SUBMISSION - NORTHCONNEX

NorthConnex EIS Submission

8 September 2014

NorthConnex Application Number: SSI 13_6136

M1-M2-5000-DR-UD-0556
NORTHERN VENTILATION FACILITY - LONG SECTION

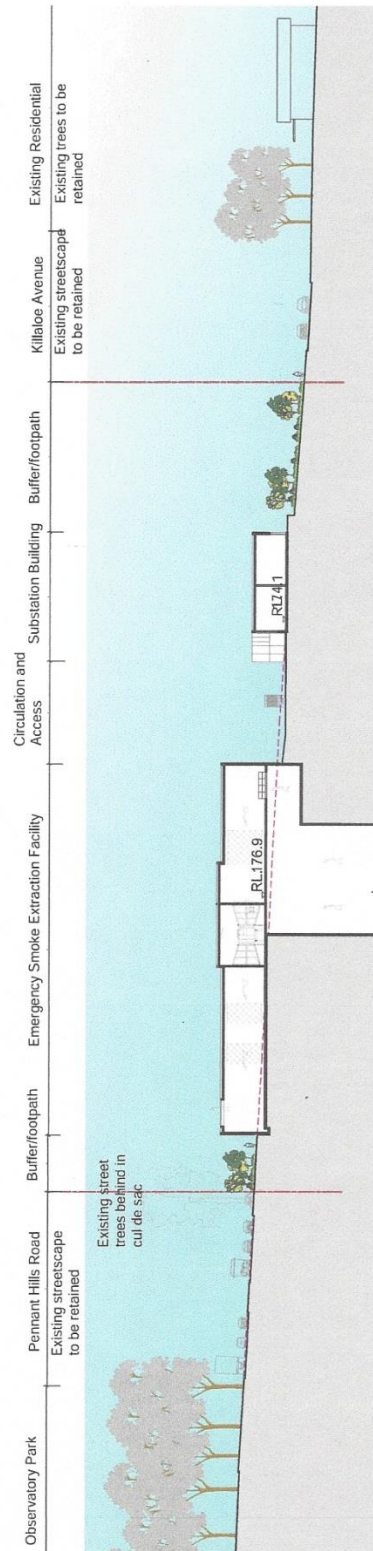
- The placement of the northern ventilation stack in the centre of a densely populated residential area in Wahroonga, where 9,300 school children will be exposed, as well as multiple aged care facilities, hospitals, businesses and homes.

- The placement of the northern ventilation stack in the Wahroonga valley where there are often low wind speeds will result in poor dispersion and community exposure to high levels of tunnel emission. A majority of heavy air pollution will have gravitation sedimentation within a distance of 50m to 1500m around the stack

The placement of the Northern ventilation stack in the Wahroonga valley where there are often low wind speeds, in particular on calm days with average wind speeds of 2 to 5 km/hour, which will result in the poor dispersion of air pollution and high emission exposure to the community. I have calculated that the majority of heavy air pollutions will have gravitation sedimentation within a distance of 50m to 1500m around the stack, refer to Appendix C - Simplified Calculation for Air Pollution Gravitational Sedimentation around Stack.

Importantly, I would like to propose an alternative 'cut & cover' tunnel extension & relocate Northbound portal & stack into bush land & industrial zone, please find the attached "Appendix E- Alternative 'Cut & Cover' Tunnel" design sketch for your consideration. I have briefly listed some advantages of my alternate design below:

- Use the 'cut & cover' concept to further extend Northbound portal & stack into industrial & bush land zone.
- Basically use existing freeway as a tunnel base & build walls/roof 'cover' to facilitate mechanical ventilation or rooftop for landscape/solar energy.
